CITY OF ALBUQUERQUE

November 13, 2013

Re: Drainage Master Plan for the Mirehaven Master Planned Community and Pulte@ Mirehaven Phase 1 Drainage Report and Grading and Drainage Plan Engineer's Stamp Date 10-11-13 (H09D017B)

TYPICAL SIDE LOT LINE SECTION
NOT TO SCALE

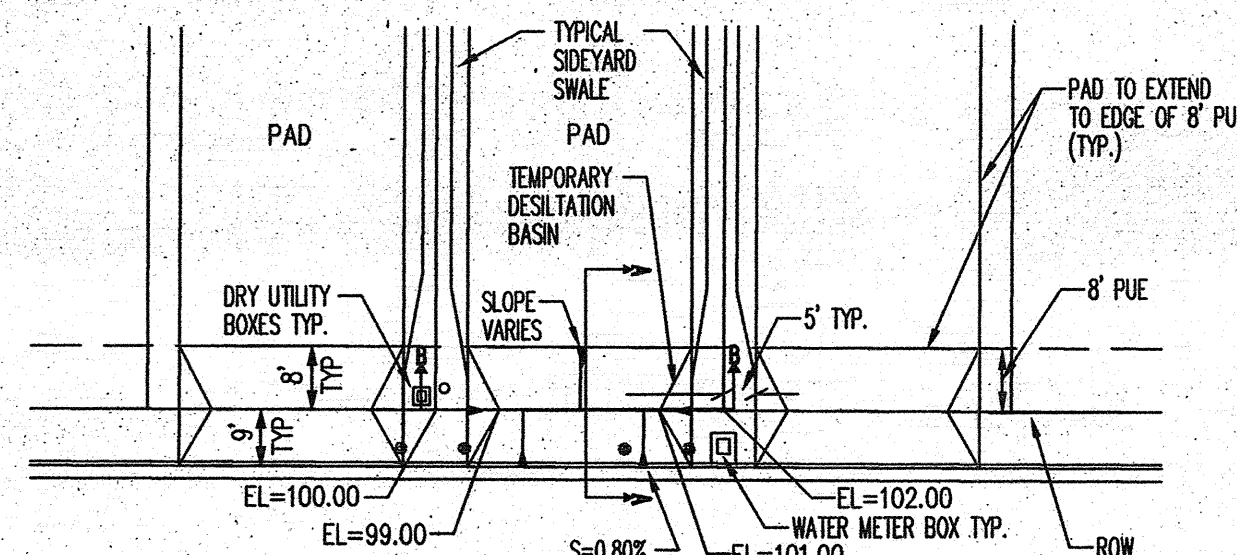
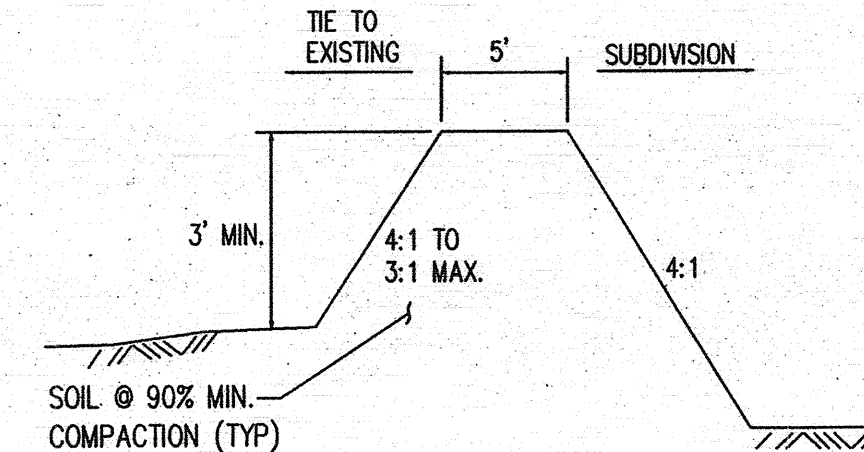
17. Berms will probably still be required with the revised submittal. They should be compacted to a minimum of 90%.
18. In the Typical Side Lot Line Section on Sheet 1, is the object of the section to not have a wall higher than 4 feet? Most residents like a 6 foot tall wall.

PULTE @ MIREHAVEN PHASE 1
OVERALL GRADING PLAN

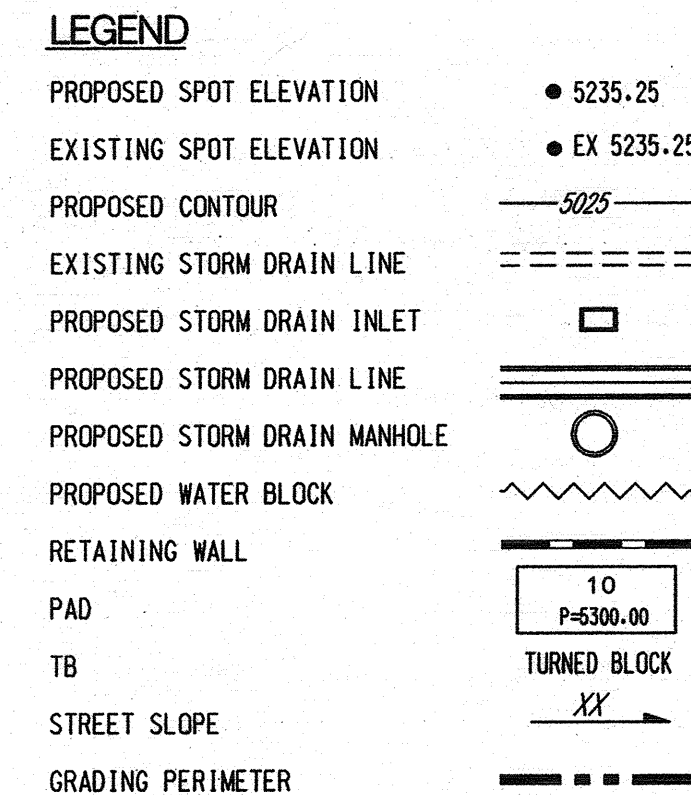
2. Provide flow-line or top of curb elevations in Tierra Pintada at regular intervals and at the intersection with Mirehaven Parkway.
3. As one proceeds up Mirehaven Parkway from Tierra Pintada, the cut/fill changes from fill near Tierra Pintada then changes to cut at approximately Lot 8 then maximizes the cut at the terminus of the street where the cut is 28 feet slopngn down to the street.

- a. Provide the street slopes of Mirehaven Parkway where it changes slope.
 - b. Street slopes should be maximized to minimize the amount of cut required.

- c. Long cut slopes tend to deposit sediment in the street, which is undesirable for numerous reasons.
 - d. It appears this cut slope would continue as Mirehaven Parkway continues south.

11. The grading plan shows Mirehaven Parkway near Tierra Pintada is super elevated to drain to the median yet the inlet is on the outside of the street.
